## **Suffolk County Council (20041323)**

Post-Hearing Submission for the Fourth Issue Specific Hearing (ISH4) on Various Environmental Matters, including Biodiversity, the Historic Environment, Landscape

## **Bramford to Twinstead (EN020002)**

16 November 2023

STOUR VALLEY EAST SEALING END COMPOUND:  
 PLAN VIEW  
 SCALE 1:200

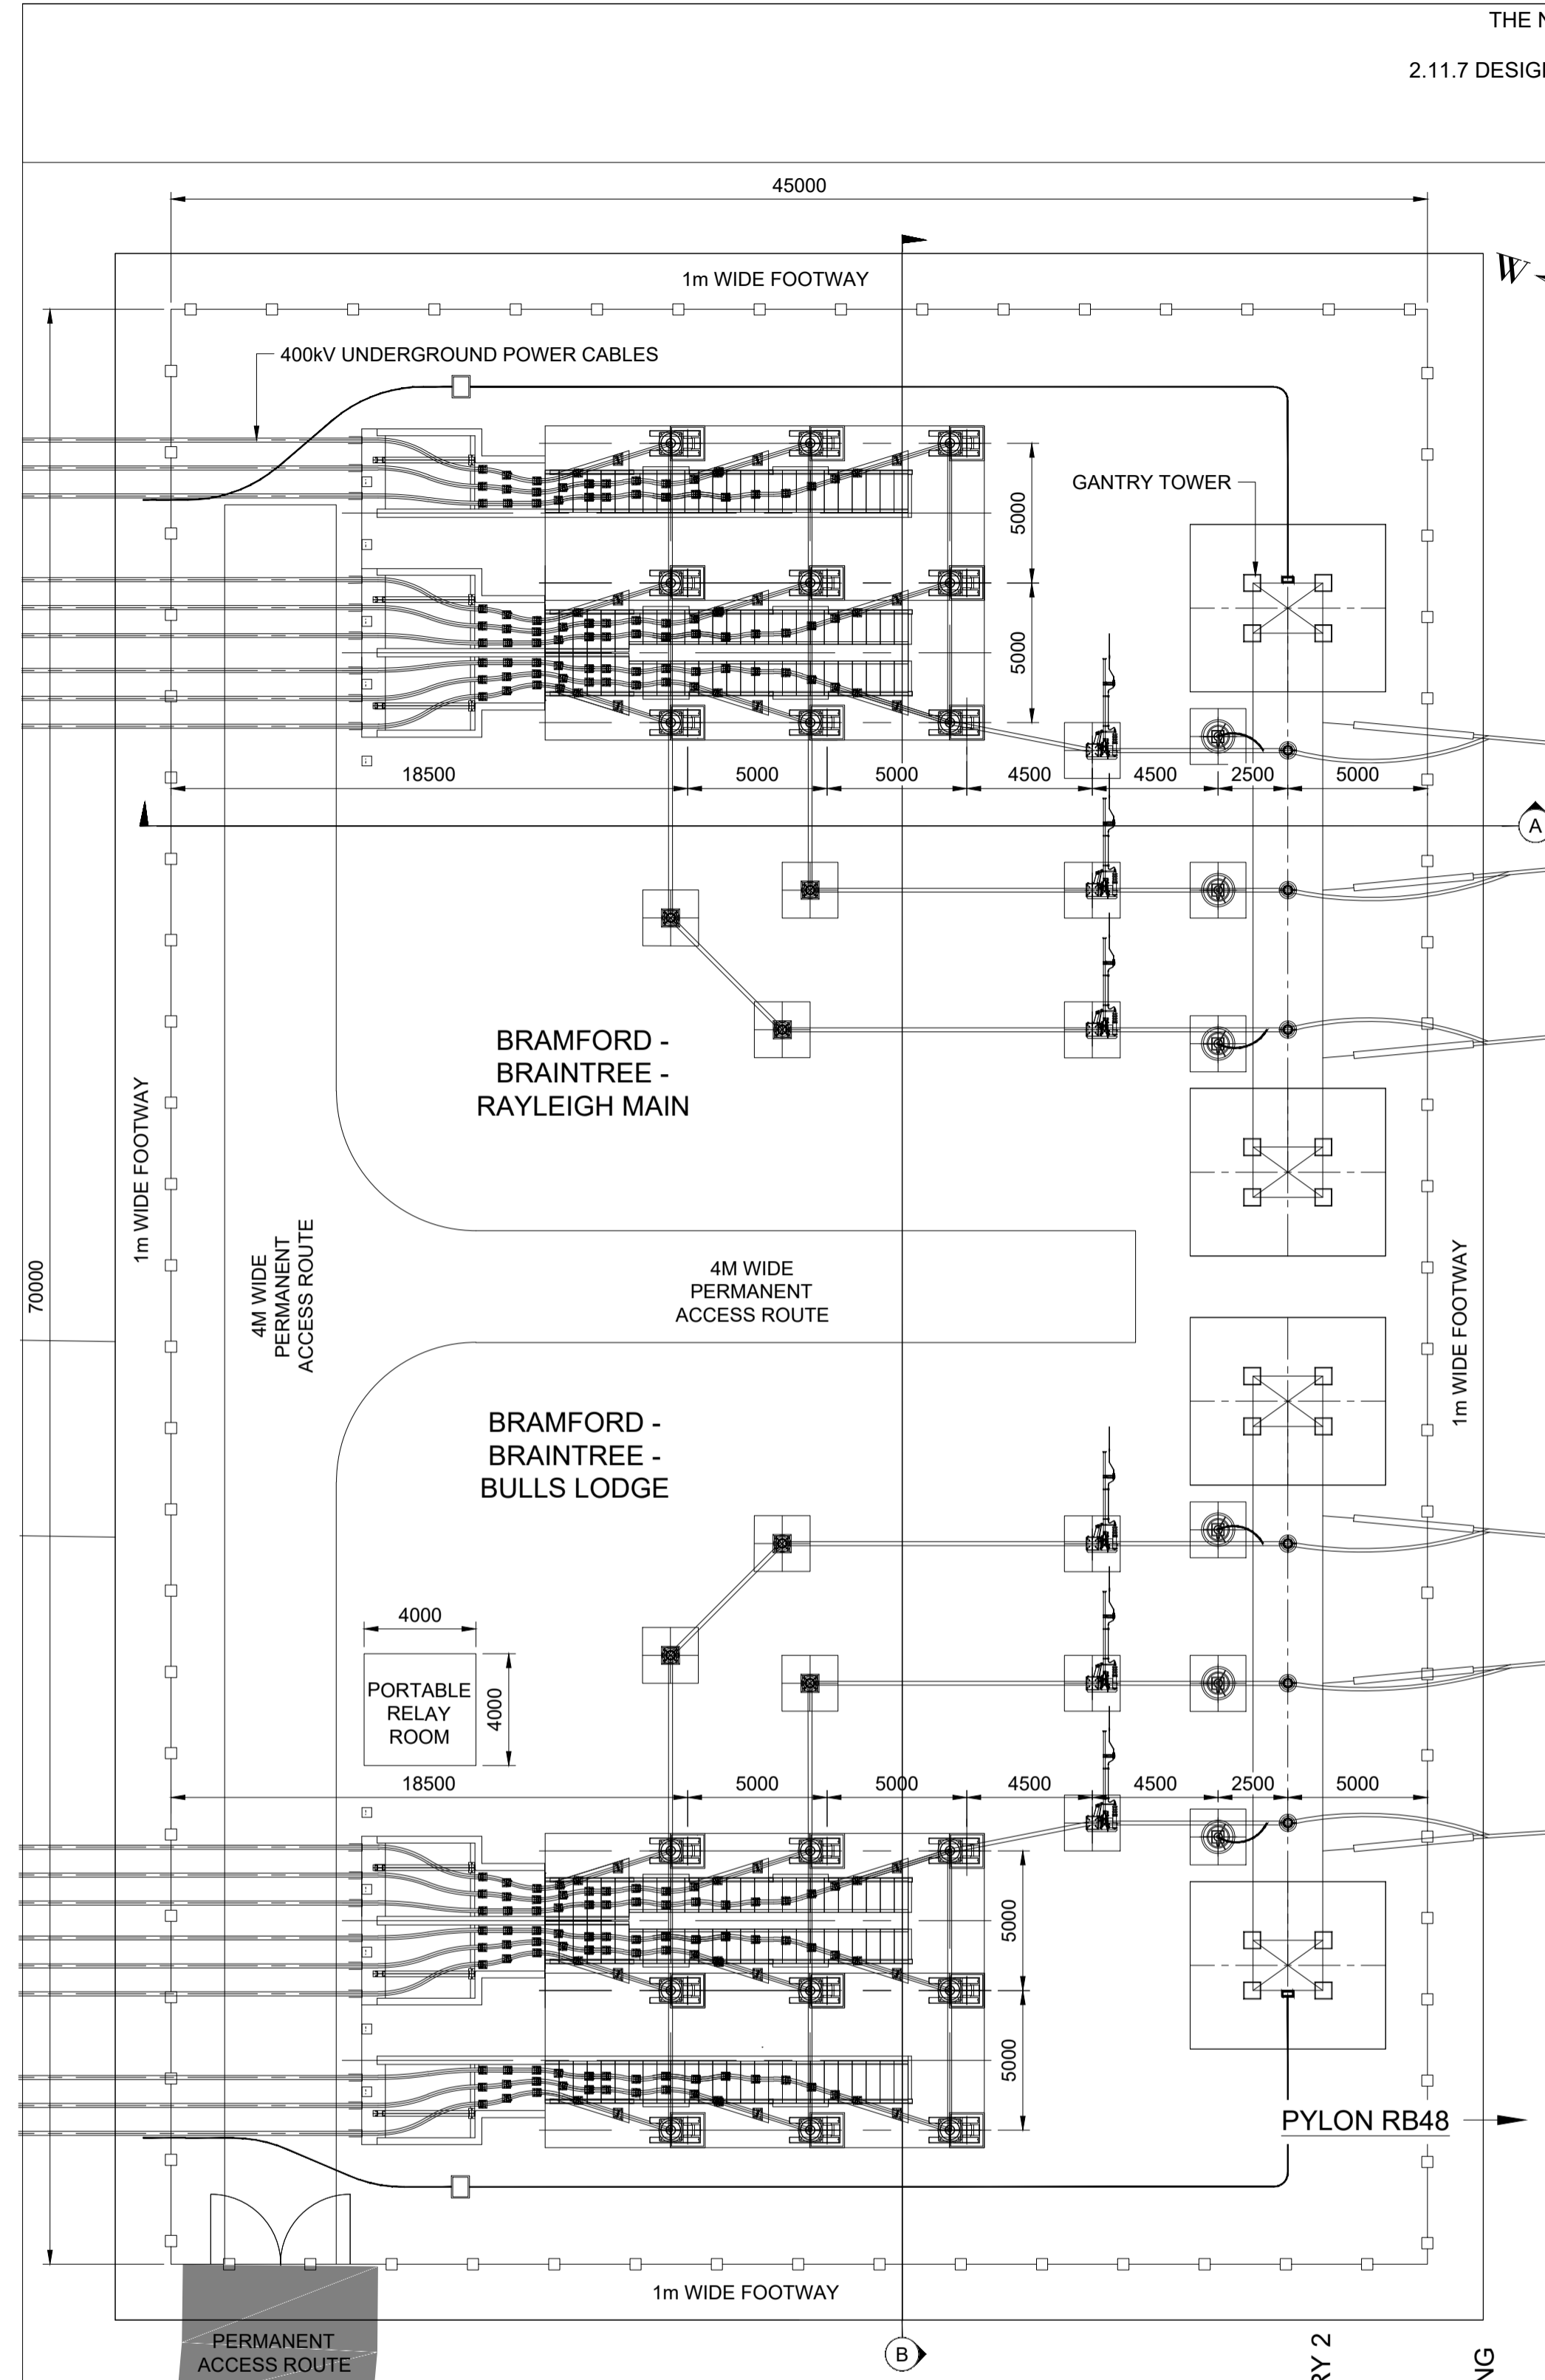
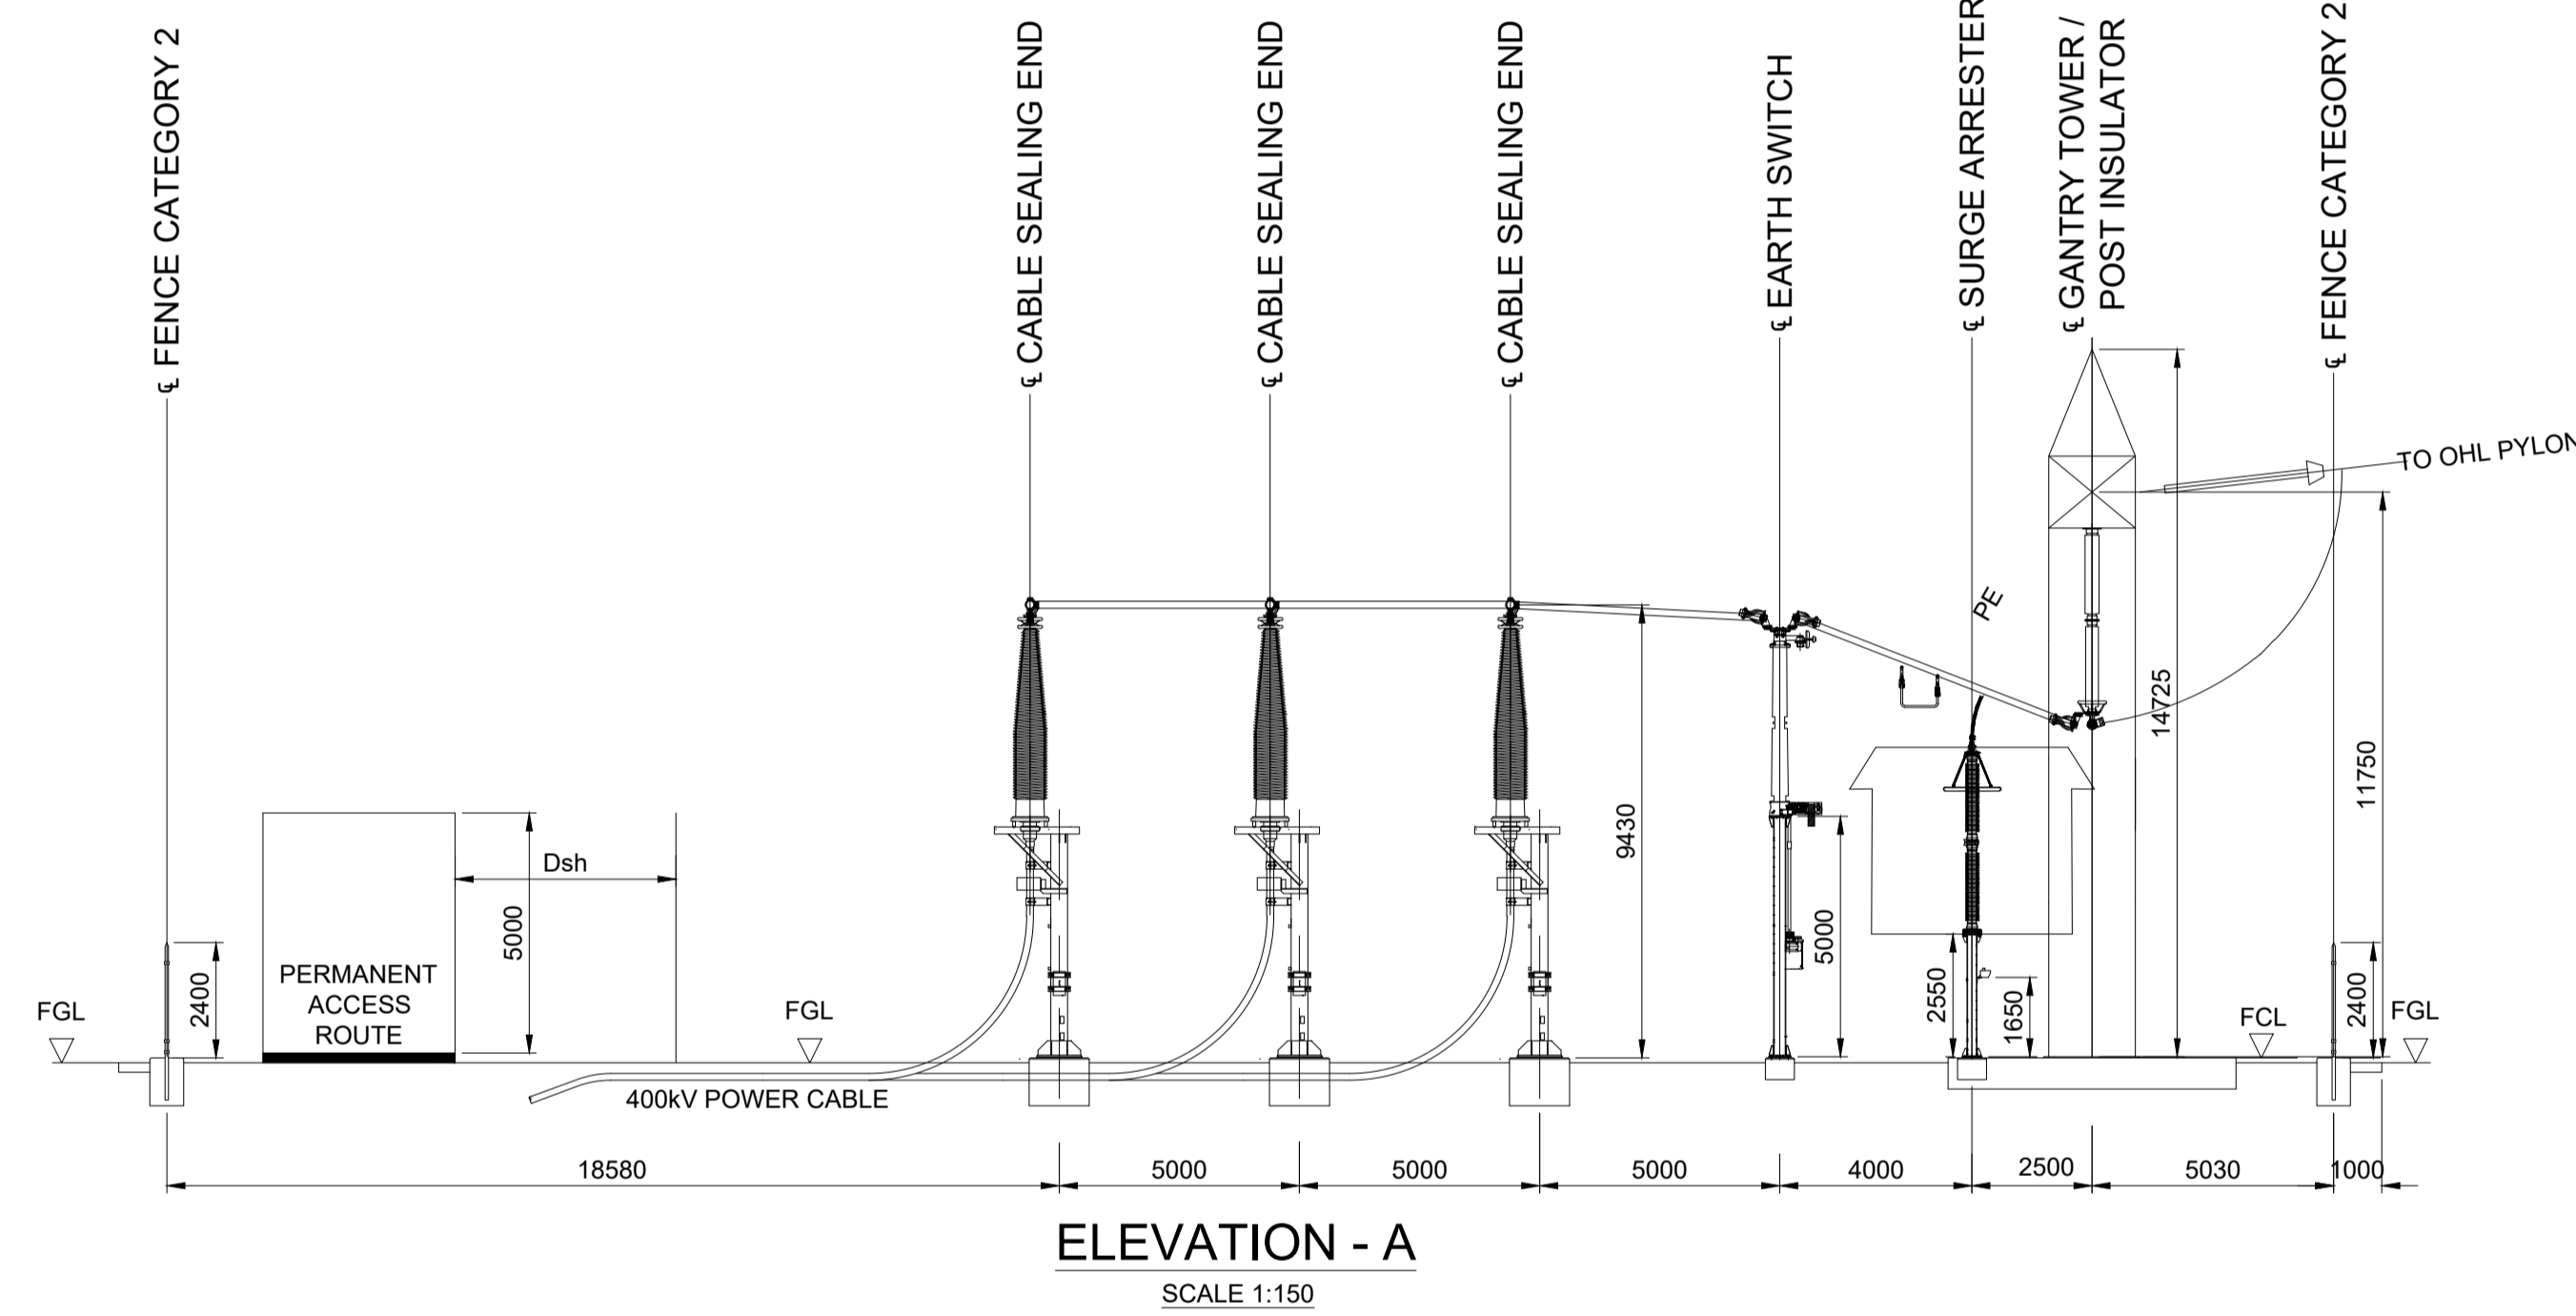
<b>PRoW network on the edge of Wickham St Paul</b>	
	<p>SCC (Landscape) is broadly content with the overall number and representativeness of the viewpoints as part of the ES. However, the Council agrees with Essex County Council and Braintree District Council that there is a lack of viewpoints in some areas, for example around the proposed haul road, and that there are a lack of viewpoints from PRoW nearer to the scheme, for example, regarding the cable sealing end compound at Workhouse Green (Stour Valley East), as identified by the Councils.</p>
<b>5.7 Sufficiency of visual mitigation for the cable sealing end compounds</b>	
	<p>SCC (Landscape) considers the visual mitigation for the cable end sealing compounds insufficient for Dedham Vale West Cable Sealing End Compound at Leavenheath and Stour Valley West Cable Sealing End Compound at Alphamstone (Essex) (LIR <b>[REP1-045]</b>, paragraphs 6.141 and 6.145).</p> <p><i>Dedham Vale West Cable Sealing End Compound at Leavenheath</i></p> <p>SCC (Landscape) welcomes the strategic positioning of the Cable Sealing End Compound north-west of the existing tree group, as this will provide useful screening. However, SCC considers that there should be continuous roadside hedge planting on the north-eastern side of the B1068 from the boundary of the apple tree farm in the east to the access track. Instead of relying on regeneration of coppiced hedges directly adjacent to the road, the hedgerow should be set back sufficiently from the road to design in the requirements of the visibility splay (i.e., north of the ditch). The hedge should have a return into the access track. The hedge to the eastern side of the access track should continue all the way to the northern end of the access track and should include hedgerow trees. The proposed planting along the A134 may (regeneration of coppiced hedge) may need to be re-assessed and contingencies made available for additional planting, should the regeneration not be successful.</p> <p><i>Stour Valley West Cable Sealing End Compound (Essex)</i></p> <p>SCC defers to the recommendation for mitigation by Braintree and Essex County Councils for additional mitigation on this site but considers that the existing roadside vegetation along the north-eastern side of the lane between Pebmarsh Road and Mabb’s Corner should be strengthened, and the existing hedges managed in such a way that they afford better screening of the cable sealing end compound. While tree planting over the cables is not possible, options for hedge planting on the southern side of the compound should be explored to create several layers of</p>

<p>mitigative planting to filter the views from the south.</p> <p>SCC (Landscape) further considers that it will be essential for the remaining cable sealing end compounds to retain the existing vegetation, ensure that that root zones are adequately protected and that landscape proposals will be fine-tuned at the detailed design stage and augmented, where required.</p> <p>At Dedham Vale East Cable Sealing End Compound at Polstead Heath the proposed hedgerow reinforcement along Millwood Road will be essential, including achieving a sufficient height of the hedge so that views form Millwood Road area screened.</p>	
<p><b>5.8 Sufficiency and security of landscape and visual mitigation and compensation planting generally</b></p>		
	<p>SCC (Landscape) considers that the proposals for landscape and visual mitigation and compensation planting generally is insufficient and insufficiently secure (reliant on Third Party agreements) (LIR <b>[REP1-045]</b>, paragraphs 6.16, 6.113, 6.117).</p> <p>SCC (Landscape) considers that the Landscape and Ecological Management Plan does not sufficiently secure re-instatement and mitigation planting. Not only is the LEMP in its current form not detailed enough to be considered the final LEMP, but it also contains fundamental flaws, which would make it unacceptable even as an Outline LEMP. Elements that are considered unacceptable include the planting schedules (species selection and percentages in the mix, sizes of tree stock, uniformity across the scheme), provisions for aftercare, such as timing to hand responsibility back to landowners, aftercare period for trees, aftercare prescriptions and periods for natural regeneration of woodland.</p> <p>SCC (Landscape) considers it would be preferable to agree a revised Outline LEMP, with detailed LEMPs being provided with the planting proposals for each section at post consent stage. SCC (Landscape) will provide a full review (tracked-change version) of the D3 LEMP <b>[REP3-034]</b> for Deadline 5.</p>
